Re : Our Ref : Raphoe Community in Action c/o Mary Harte & Others

Your Case Number ABP – 315708 – 23

P.A. Reg Number 2250933

Further to your correspondence to us dated 09 May 2024, we wish, on behalf of our Clients, to make the following observations in respect of the additional information submitted to the Bord by the Applicant, Mr Patrick Bonar, dated 15th March 2024.

Drawing Title:
Realignment of Junction at R236-6

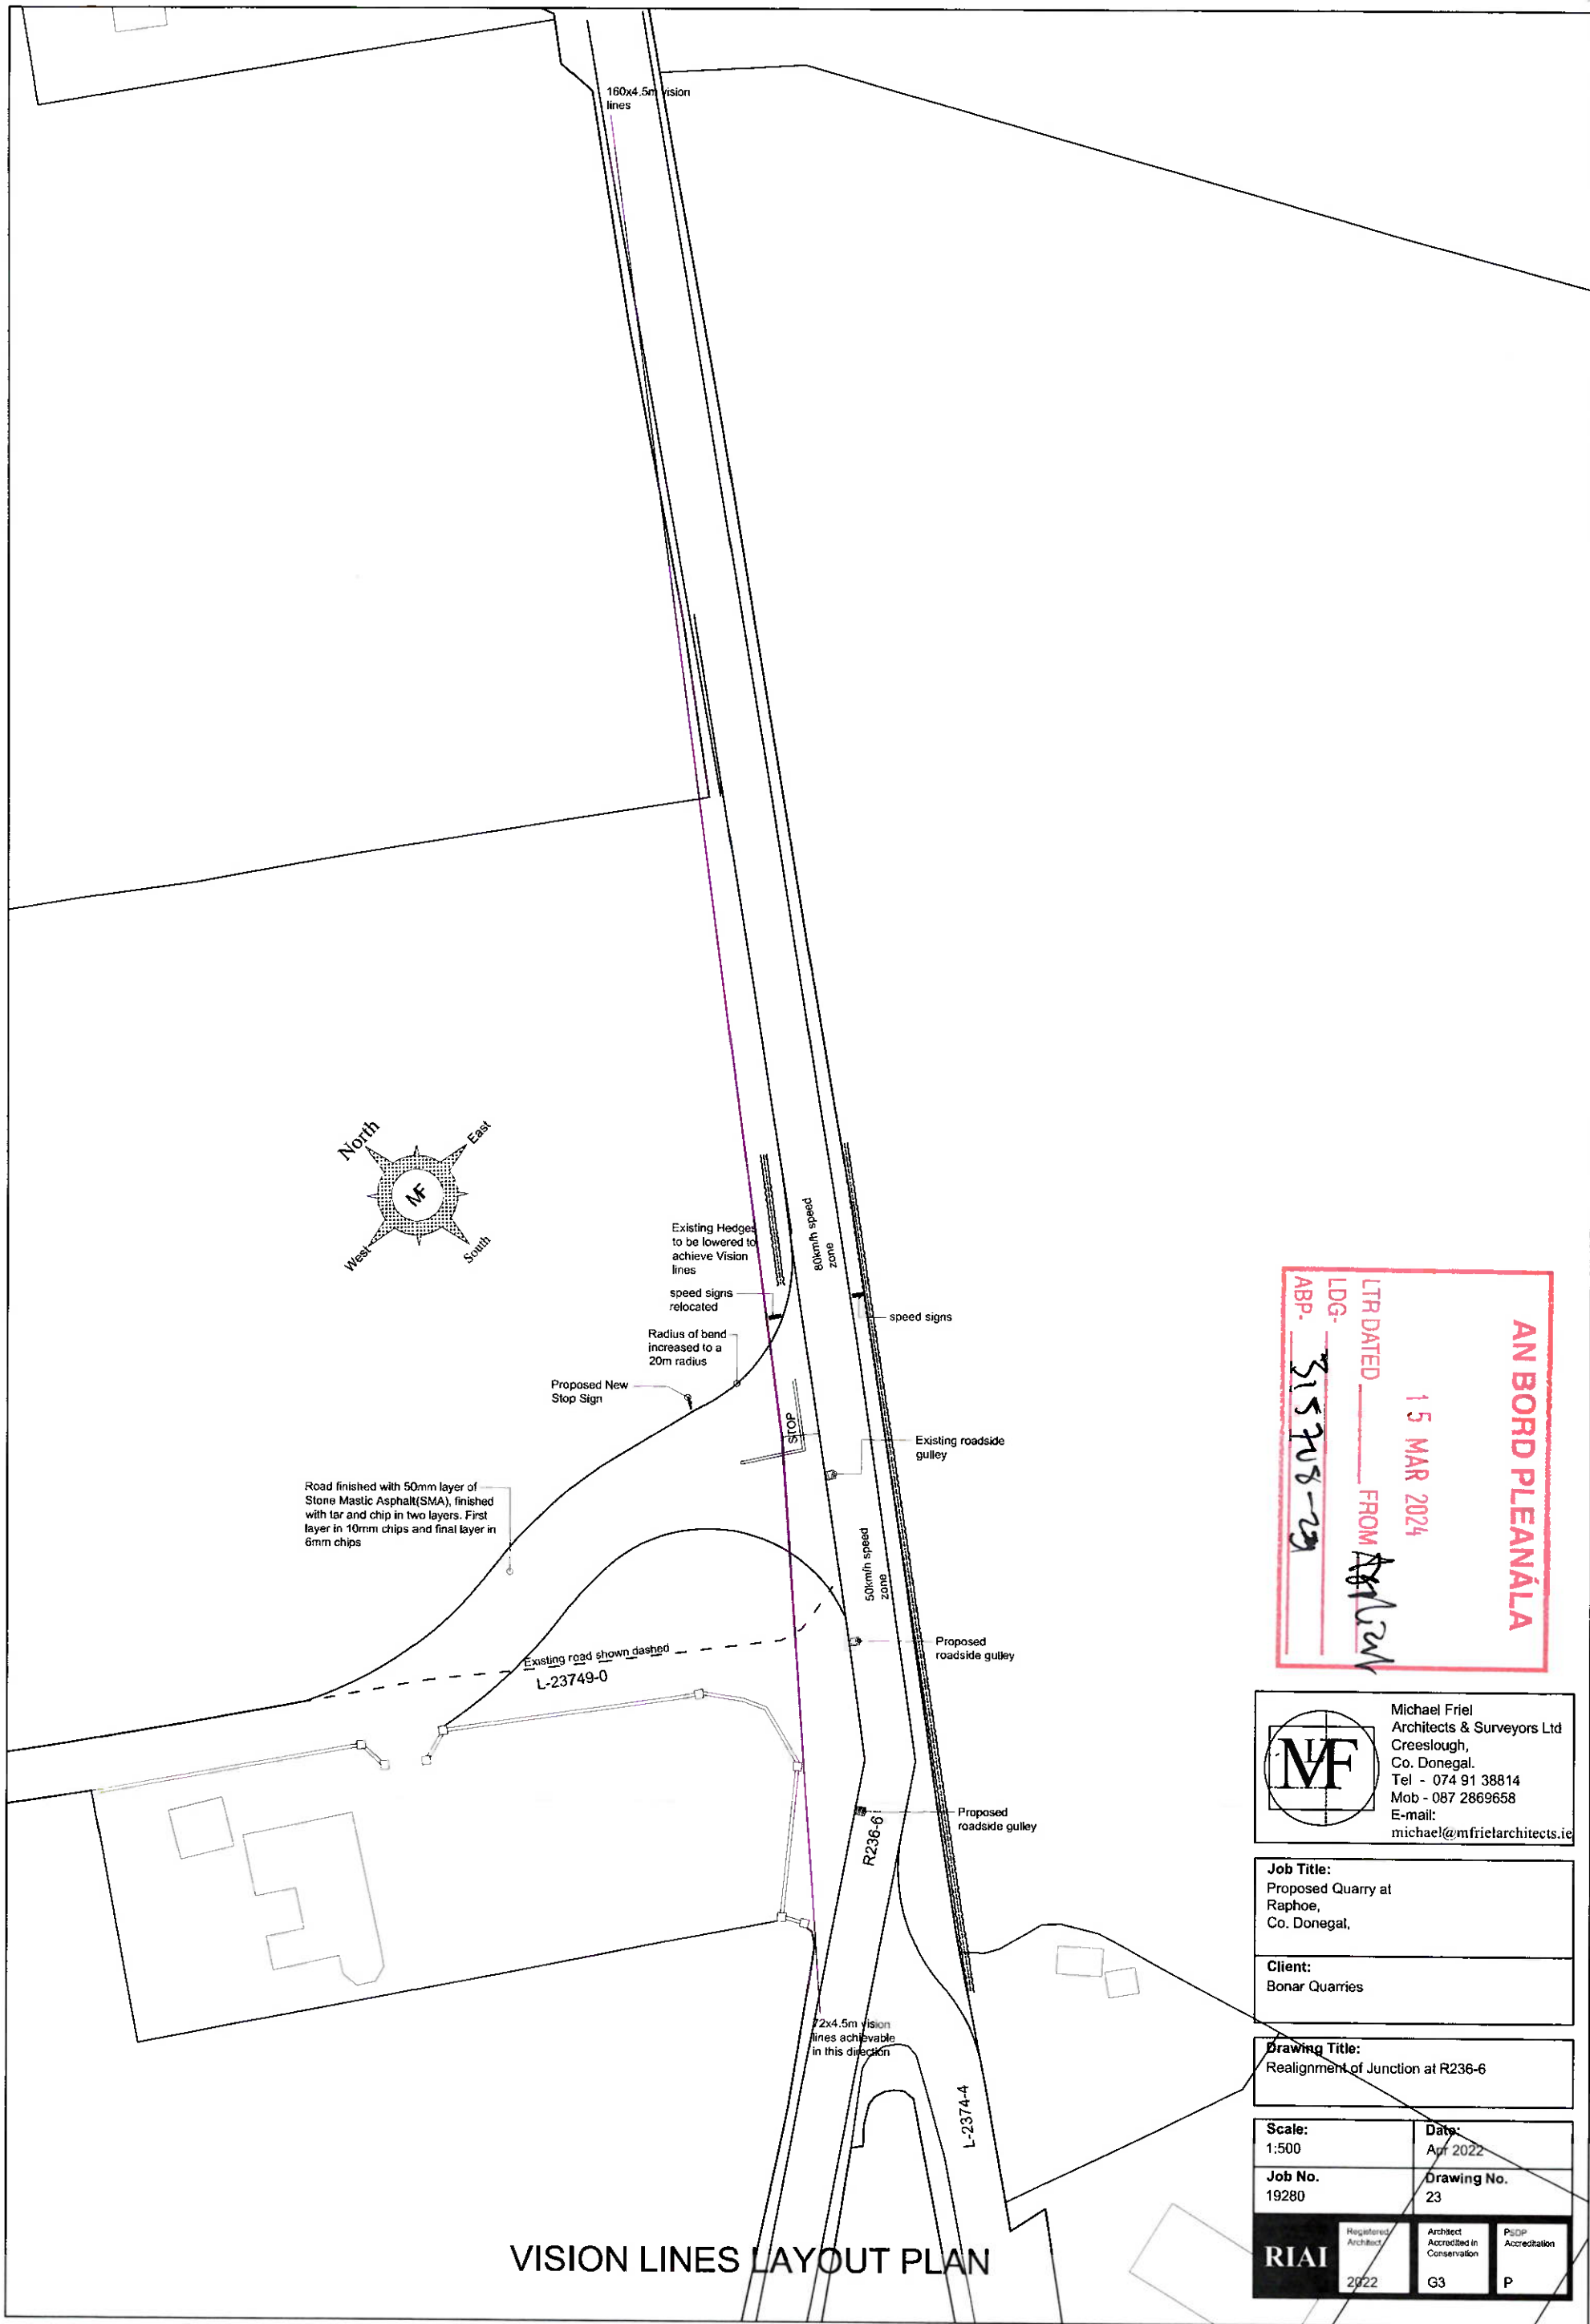
4.01 In our original submission in respect of this appeal, we did not raise the issue of access, vision lines, etc., as the proposal had the blessing of the road engineers in Donegal County Council whom we assume act in the interests of traffic safety, irrespective of who the applicant is. However, thanks to the queries by the Bord regarding the access, we are informed that the existing county road, the L 2374, is no longer to be used by the Applicant as access to the proposed quarry. Instead he is proposing a new access ***which is outside the original site submitted.***

4.02 This new entrance, like the current county road access, shows a vision line of 72m. on the south west side [Raphoe Town side] and 180 m. on the other side. The standards set out in the County Development Plan 2018 – 2024, Part B, Appendix 3, require visibility lines of between 120m and 160m in respect of development like that proposed, see Doc. 4, enclosed. ***[It is argued that the higher figure must apply in this case as there is a sharp***

corner on the south west side [Raphoe Town side] of the new entrance and there exists another county road opposite the new entrance, the L2374-4. Furthermore, the R 236-6 is a regional road, being the main road between Derry and Galway, through Raphoe Town, and the existence of an existing domestic entrance on this south west side, home of Mr Joe Magee, [marked 'Z' on Doc. 5, enclosed] adds to the traffic confusion at the proposed entrance which will undoubtedly pertain.]

4.04 The Applicant has not submitted all relevant letters of consent in respect of the new access arrangements. He has submitted a letter from Mr Andrew Magee consenting to the provision of sightlines by cutting hedges, but that can only be over his land, marked 'AM' on

Doc. 5, enclosed. However, the Applicant's newly submitted plan shows vision lines which trespass on land owned by Mrs Thompson, [home and land marked 'X' on Doc. 5, enclosed.] It is this sort of misinformation by the Applicant which adds to the serious concerns the opponents of this proposal have, and who will, for decades, have to police the quarry operations if permission is granted. That, we submit, is not how planning ought to be administered.
